Rezoning Transportation Analysis

Petition Number: 2021-119

Revision Log:

Date	Description
09-23-2021	First Review (KP)
11-22-2021	Second Review (KP)
12-20-2021	Third Review (KP)

SHEET NUMBER  
**RZ-1**

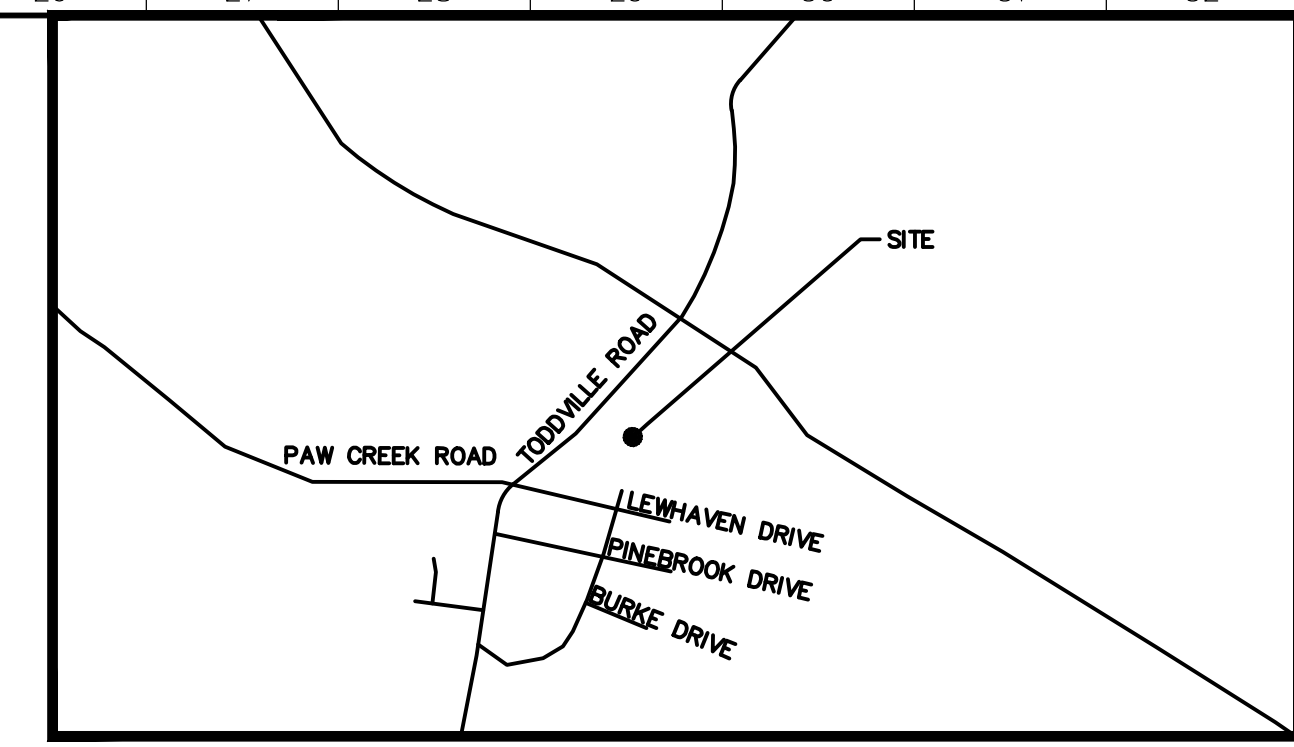
11. **New Comment as a result of the 11-15-2021 Site Plan:** Revise the site plan by modifying the U-02 cross section, shown on sheet RZ-1, to incorporate 6-foot sidewalks as labeled and dimensioned on the site plan.

10. ~~**New Comment as a result of the 11-15-2021 Site Plan:** Revise the site plan and conditional notes to commit to provide right in right out ingress and egress at the intersections of Private Alley D and Public Street A and Private Alley A and the approved public street associated with the Freedom Flats Multifamily Development (LDGP-2020-00201). A porkchop island shall be utilized on Private Alley D~~

and Private Alley A, with appropriate ADA pedestrian accommodations, to direct the right in right out movements.

Update to Comment as a Result of the 11-15-2021 Site Plan: Revise Site Plan Note 2 to: "Developer will coordinate with NCDOT, during permitting, to construct a left turn lane on northbound Freedom Drive to turn onto Woodford Lane. The left turn lane will be subject to NCDOT standards and approval"
